Re. Alterations to Salisbury Memorial Hall grounds &
93 Ribchester Rd - BB1 9HT -

I write to register my objection to part of
the plan/development 3/2022/0628, Salisbury Memorial Hall.

PROPOSED ENTRANCES

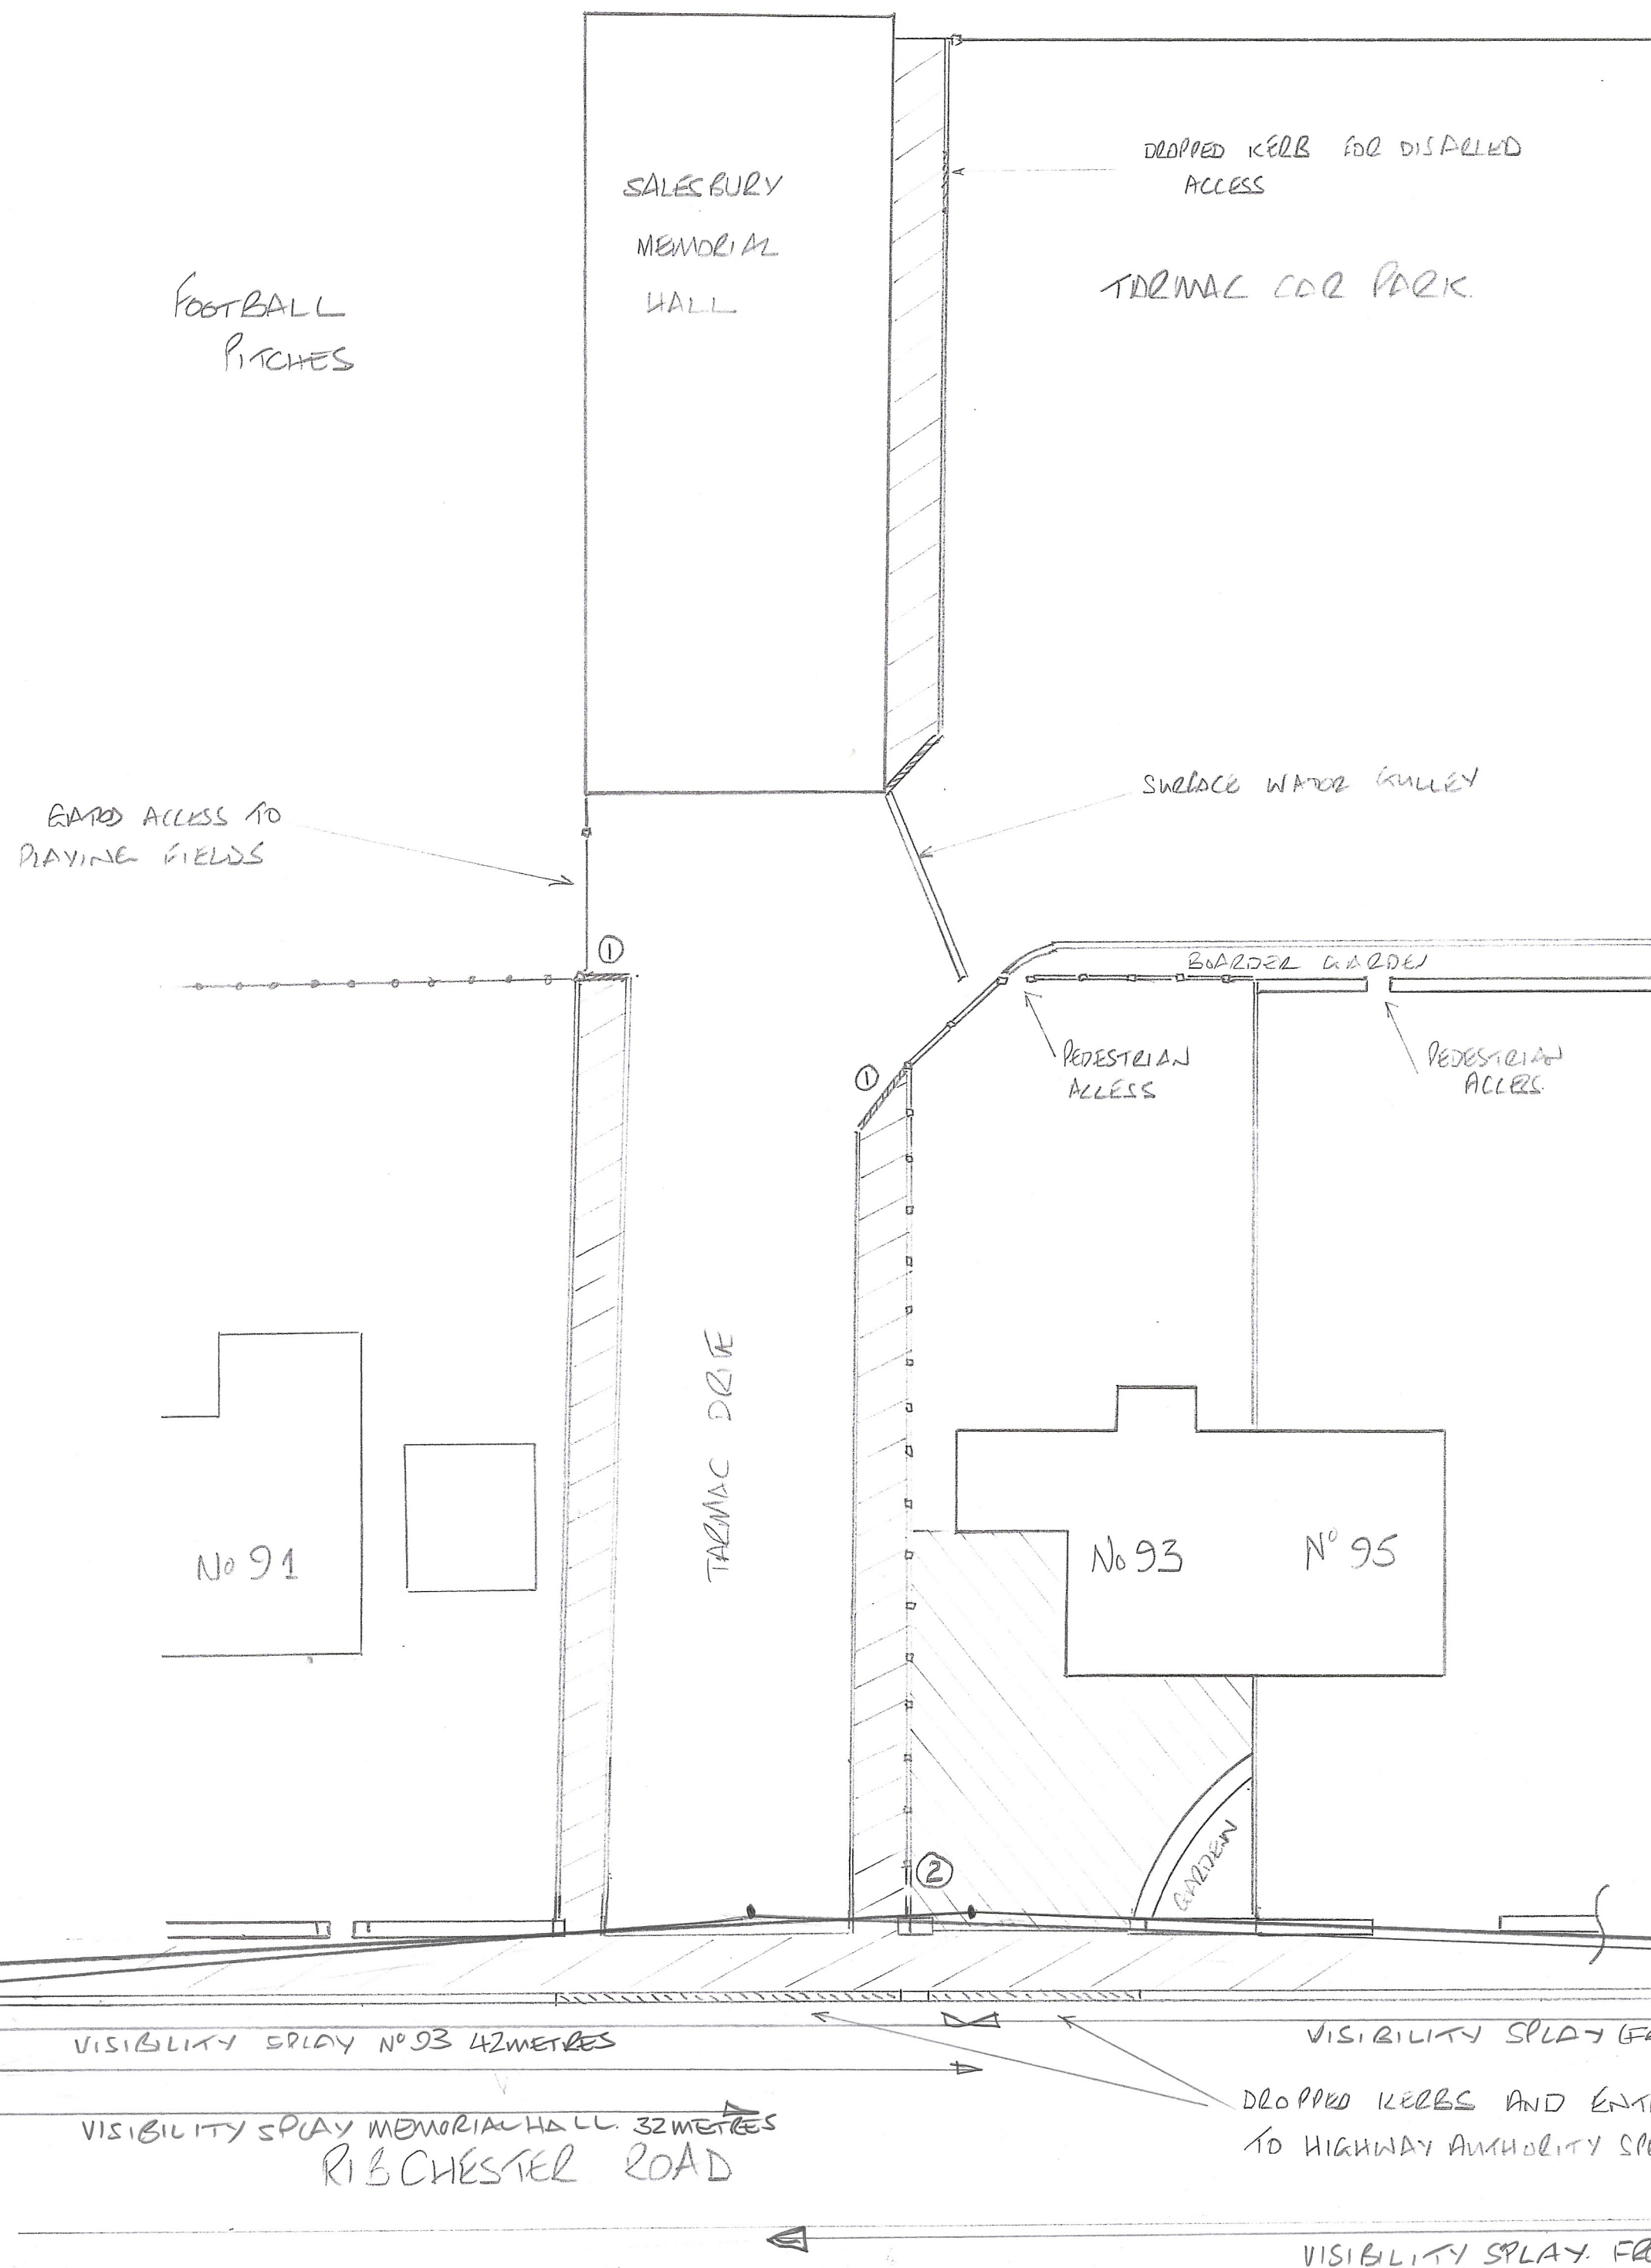
1. I have no objection to the redevelopment of alterations planned for the enclosed boundaries of the hall.
2. My major concerns embrace HEALTH & SAFETY.
3. The proposed widening of the existing entrance by demolishing the boundary stone wall could prove very DANGEROUS to pedestrians and vehicles using Ribchester Rd footpath crossing the said entrance.

6. Hence, to permit the widening of the Memorial Hall driveway entrance permitting a 2-WAY TRAFFIC FLOW could exacerbate the problem with egress onto Ribchester Rd. ——— POTENTIAL HAZARDOUS! 'AN ACCIDENT WAITING TO HAPPEN'!

7. The present width of the said entrance provides SAFE CONTROL for traffic entering/exiting the hall grounds. Also pedestrian SAFETY is paramount as they pass the entrance.
